From: Ben Williams <[REDACTED]>
Sent: 25 January 2021 09:13
To: Laura Tyler
Subject: Re: -20/01000/FUL Delrena
Attachments: 005 EXISTING SITE PLAN.pdf; 200 PROPOSED ELEVATIONS.pdf; 001 SITE LOCATION PLAN.pdf; 050 PROPOSED SITE PLAN.pdf; 100 PROPOSED FLOOR PLANS.pdf

The team leader has marked up on the attached plan where she thinks there could be encroachment, If you could clarify this.

Title:
**Existing
Ground Floor Plan**

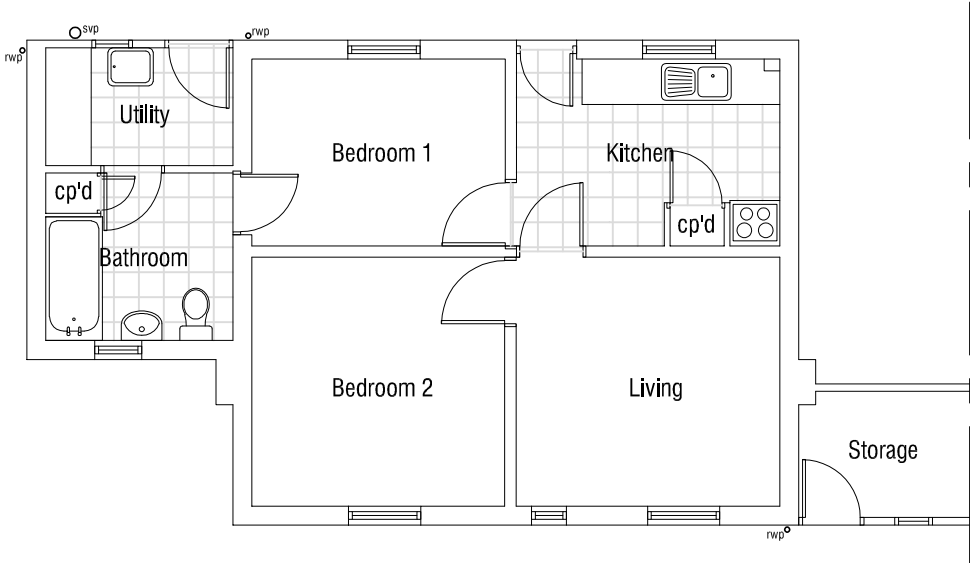
One other thing that has been picked up is the footprint of the dwelling as shown on the site location plan is different to that shown on the existing floorplan.

Hi Laura, attached amended drawings which include an updated site location plan which matches the footprint of the building, there is an outbuilding/shed which is inaccessible in the corner which is probably causing confusion. The site plan is updated to show this as with the proposed scheme which does not overhang the boundary.
